3.15.09
TO: KITTITAS County COMMUNITY DEVELOPMENT SERVICES
FM: ROGER OVERBECK

RE: SHORT PLAT APPLICATIONS SP-09-00001 - SP-07-15
SP-07-13 - SP-07-12

TO: Allison Kimball, Community Development Services
FROM: Christina Wollman, Planner II *CW*
DATE: March 3, 2009
SUBJECT: Grove Short Plat SP-09-00001

GROVE SHORT PLAT

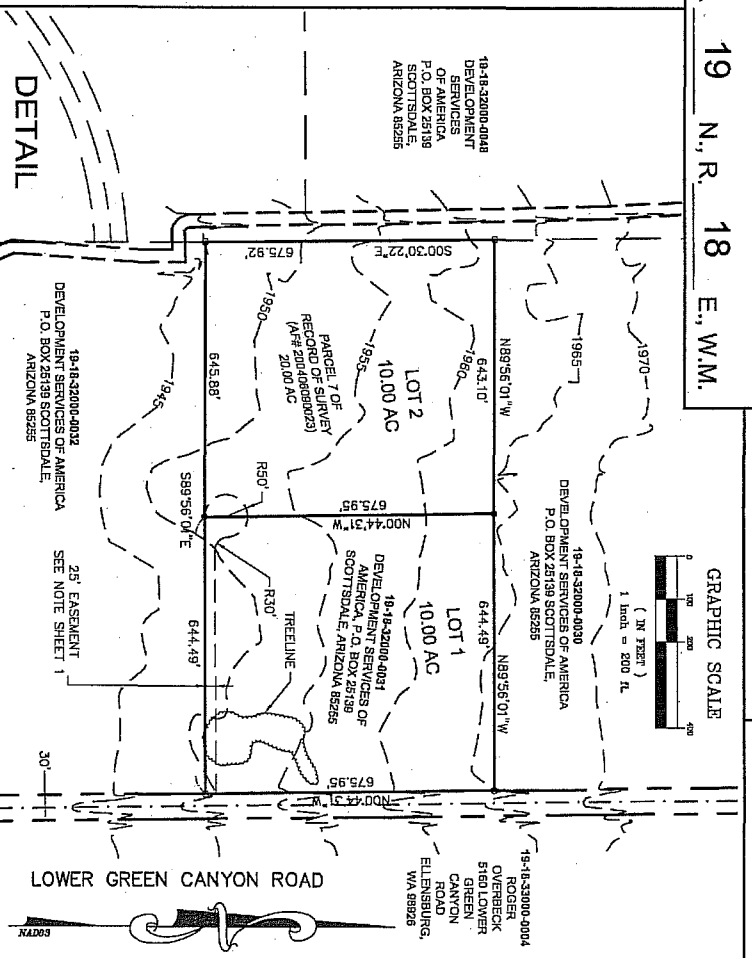
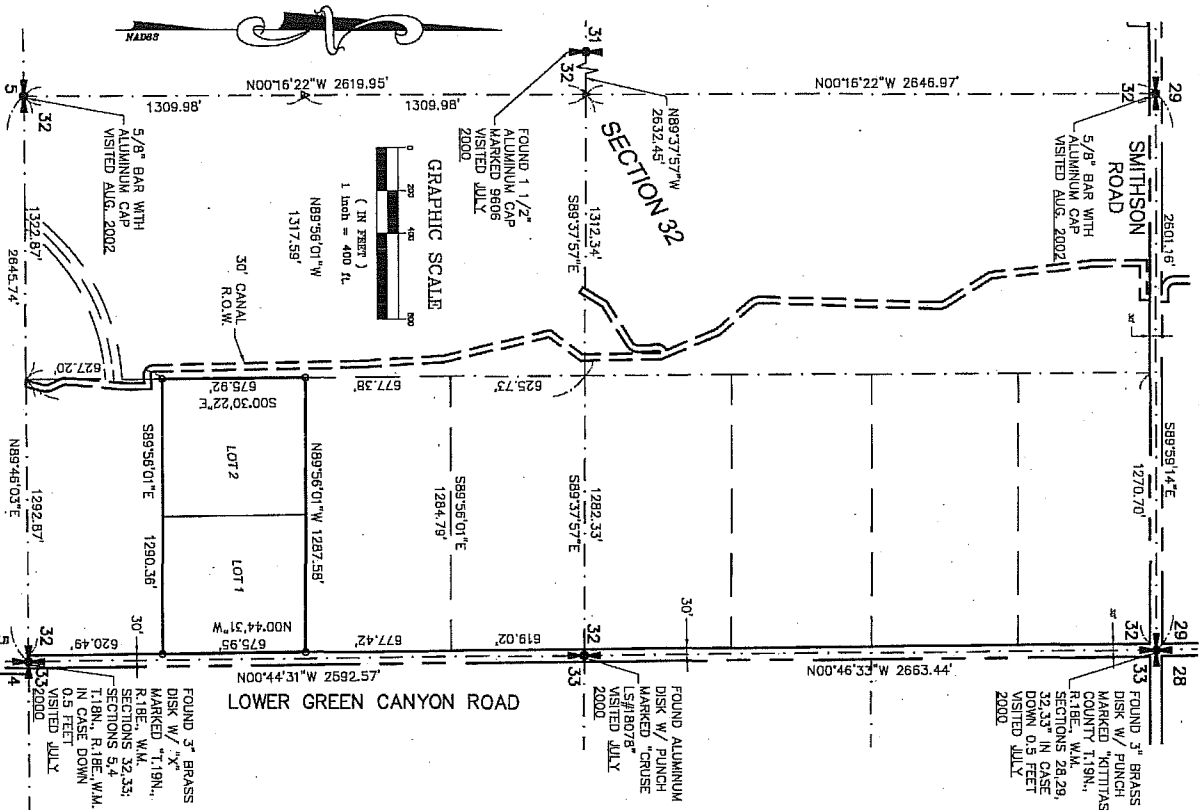
2. Plat Notes: Plat note #3 shall be removed and the following plat notes added.
 - a. Maintenance of the access is the responsibility of the property owners who benefit from its use.
 - b. Any further subdivision or lots to be served by proposed access may result in further access requirements. See Kittitas County Road Standards.
 - c. A public utility easement 10 feet in width is reserved along all lot lines. The 10 foot easement shall abut the exterior plat boundary and shall be divided 5 feet on each side of interior lot lines. Said easement shall also be used for irrigation.
